Ref : Garage extension with new vehicular access. 2 Queensfield East, West Meads,
Bognor Regis, West Sussex, PO21 5RN. Application Number AW/55/13
(Resubmission following - AW/321/12. Refused)

We refer to resubmitted planning application AW/55/13 (following refusal AW/321/12.) for a 'Garage Extension with new Vehicular Access' to 2 Queensfield East, West Meads, Bognor Regis. As a resident, having lived opposite for 30 years, we reiterate many things we said of the previous application and therefore very strongly object to any development with an additional access on to Trinity Way for the reasons indicated below.

Plan
1 : 50

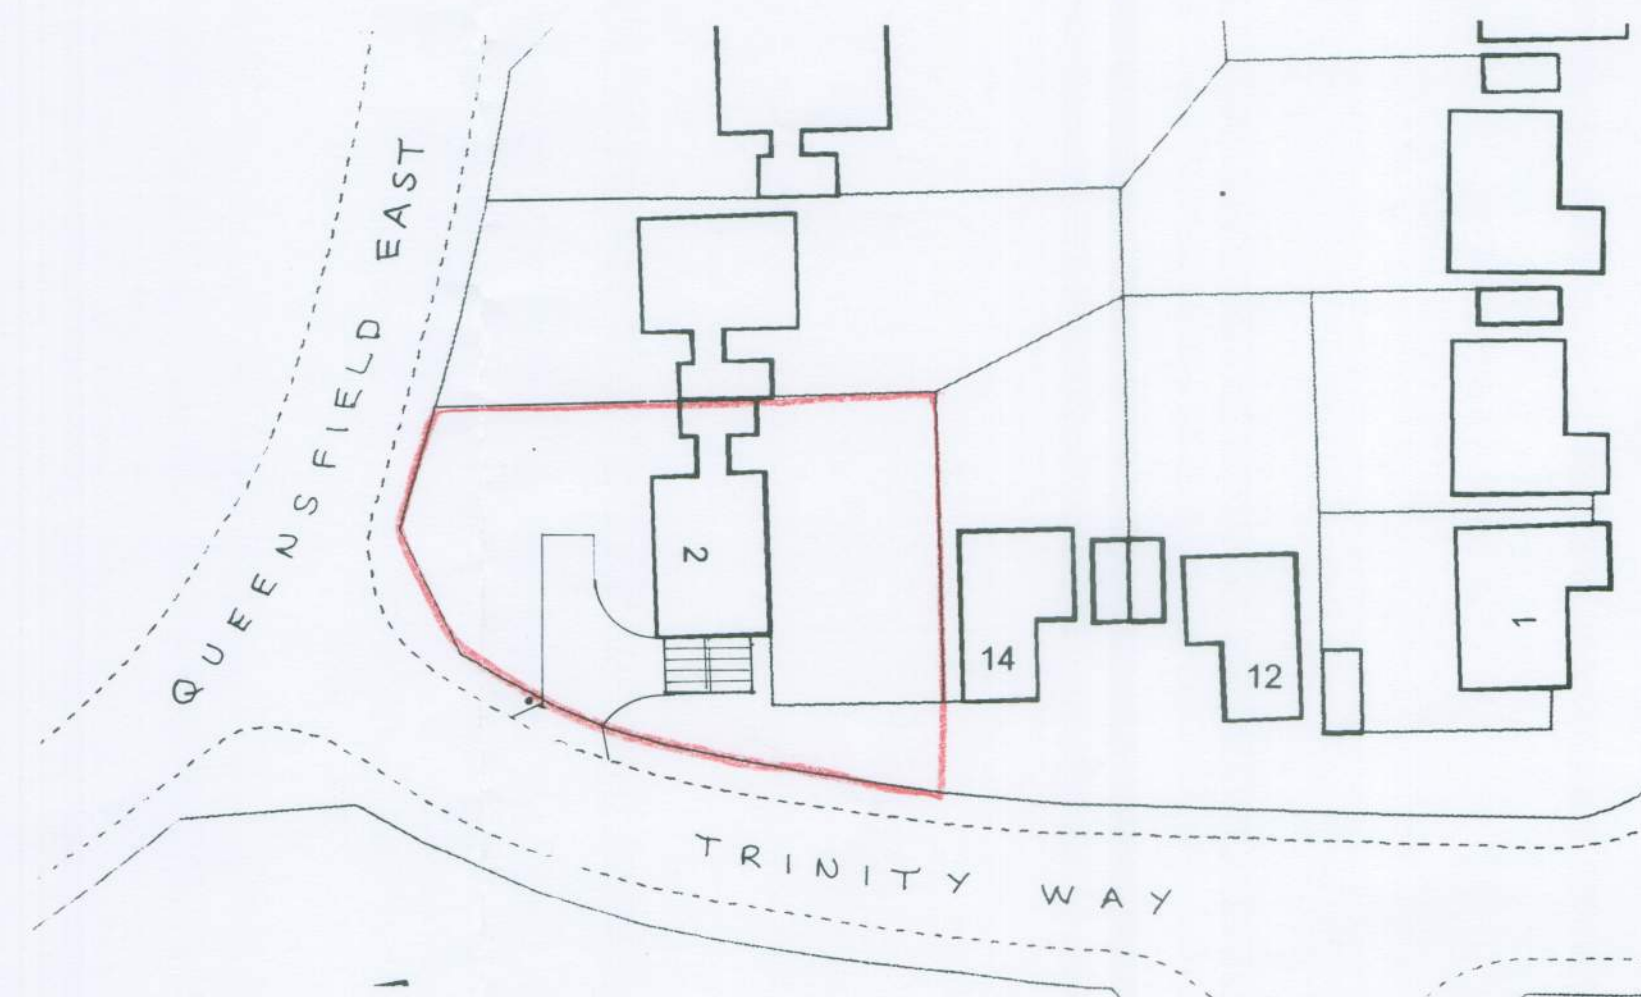
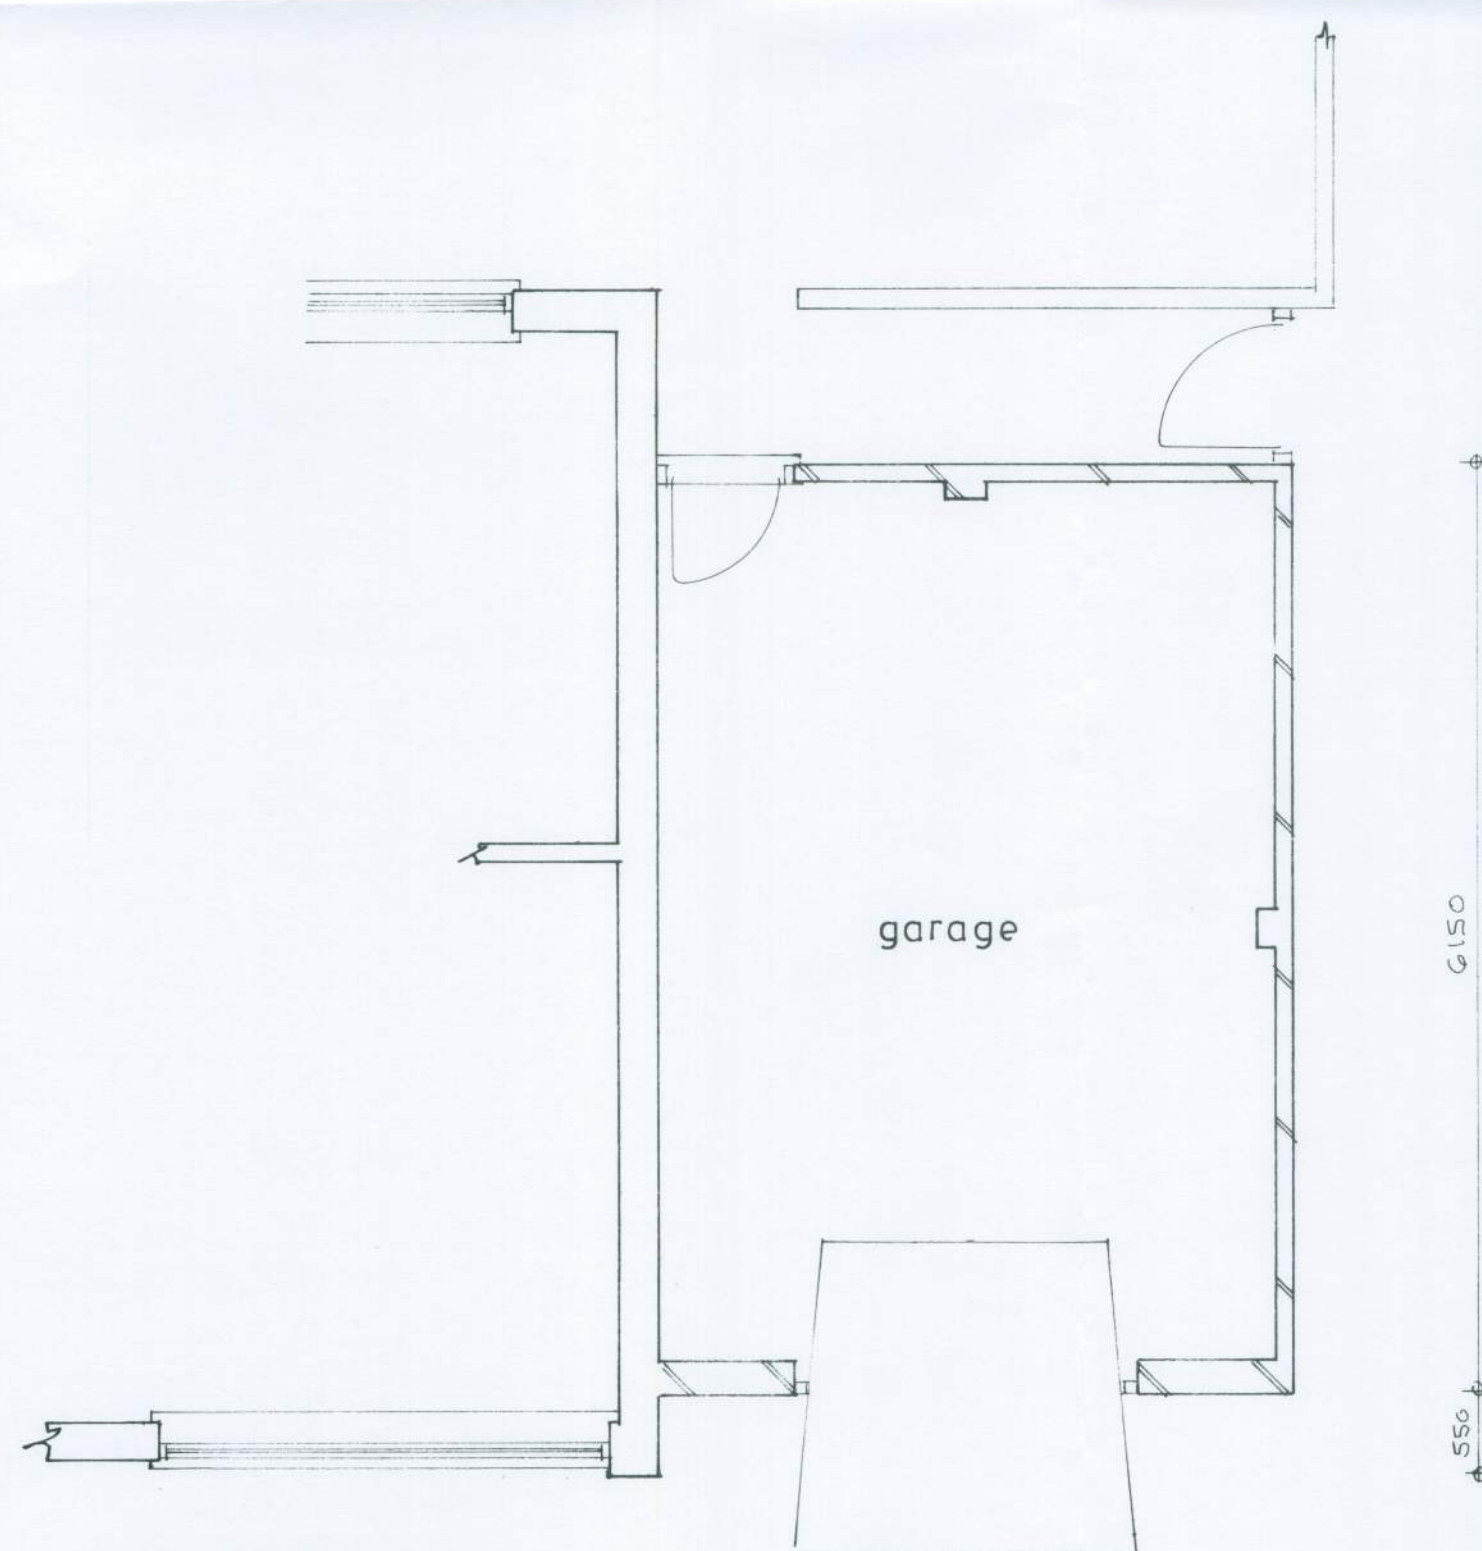
This proposal completely disregards the original open frontage areas around which this estate was designed. No consideration to the original Building Line which the proposed mass protrudes by 4250mm the width of the garage. Also, travelling down Trinity Way towards The Precinct, the Trinity Way to Queensfield East sight/visibility line would be greatly reduced and endanger vehicular movement more than at present.

There is also, to be taken into account, a lamp post at the back edge of the footpath and an existing utilities inspection cover that would be in the middle of the footpath crossing.
